Application No: EP/68/21/HH
Site Address: Merrydown Kingston Lane East Preston BN16 1RP
Description of works: Erection of timber framed detached garage with ancillary accommodation on first floor, installation of electric gated entrance, erection of new brick garden walls and extension to existing driveway and hardstanding.

Thank you for your internet representation made on 22nd July 2021 which has been recorded as an objection with the comments as follows:

I am commenting on behalf of the East Preston and Kingston Preservation Society.

DRAWING TITLE
Roof Plan as Proposed
Planning Issue

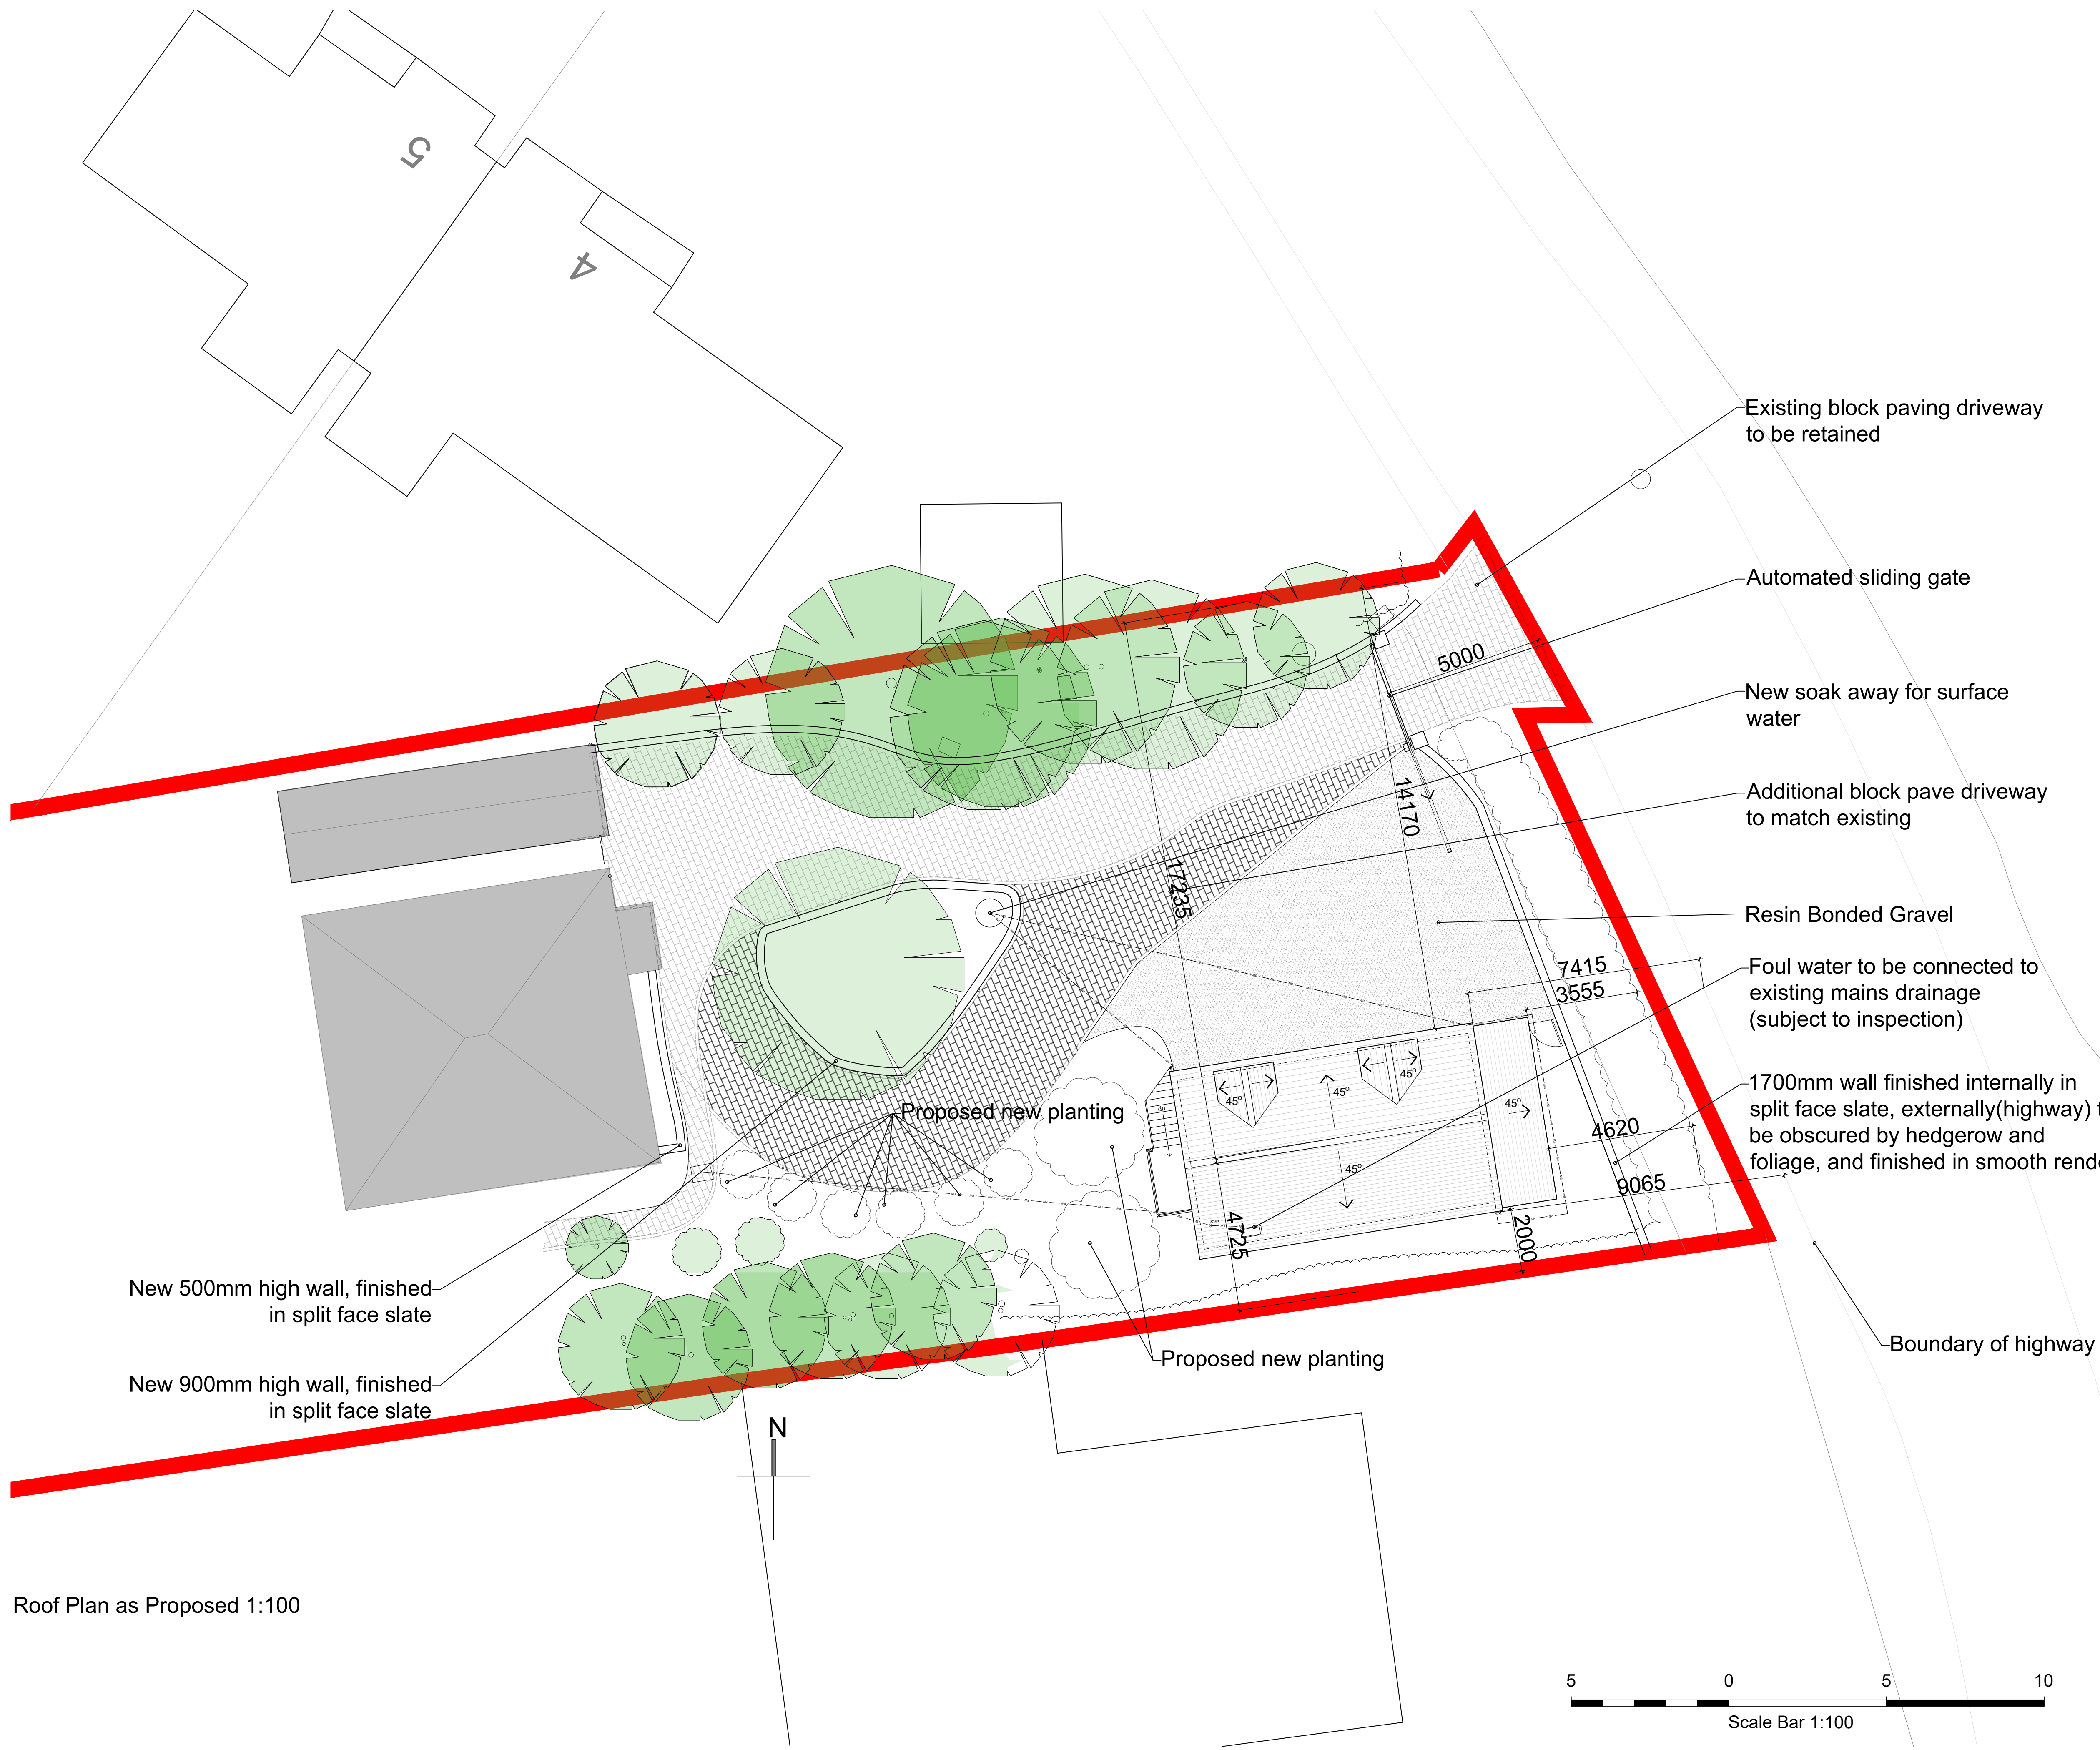
The construction of the proposed new building would therefore compromise the characteristics of the area. The Society's first preference for the outcome of this application is that permission for an additional building should be refused.

If Arun is minded to approve the construction of an additional building in this Area, it should ensure that it is sited so that its position reflects the character of the area, to conform to policy D DM1 of the Local Plan. The position now proposed, far ahead of the existing houses, is wholly inappropriate. It should be aligned with the existing houses. The materials used in the new building should reflect the colour and texture of the materials in the adjoining buildings. to conform to Policy D DM1 and Policy 1 of the East Preston Neighbourhood Plan.
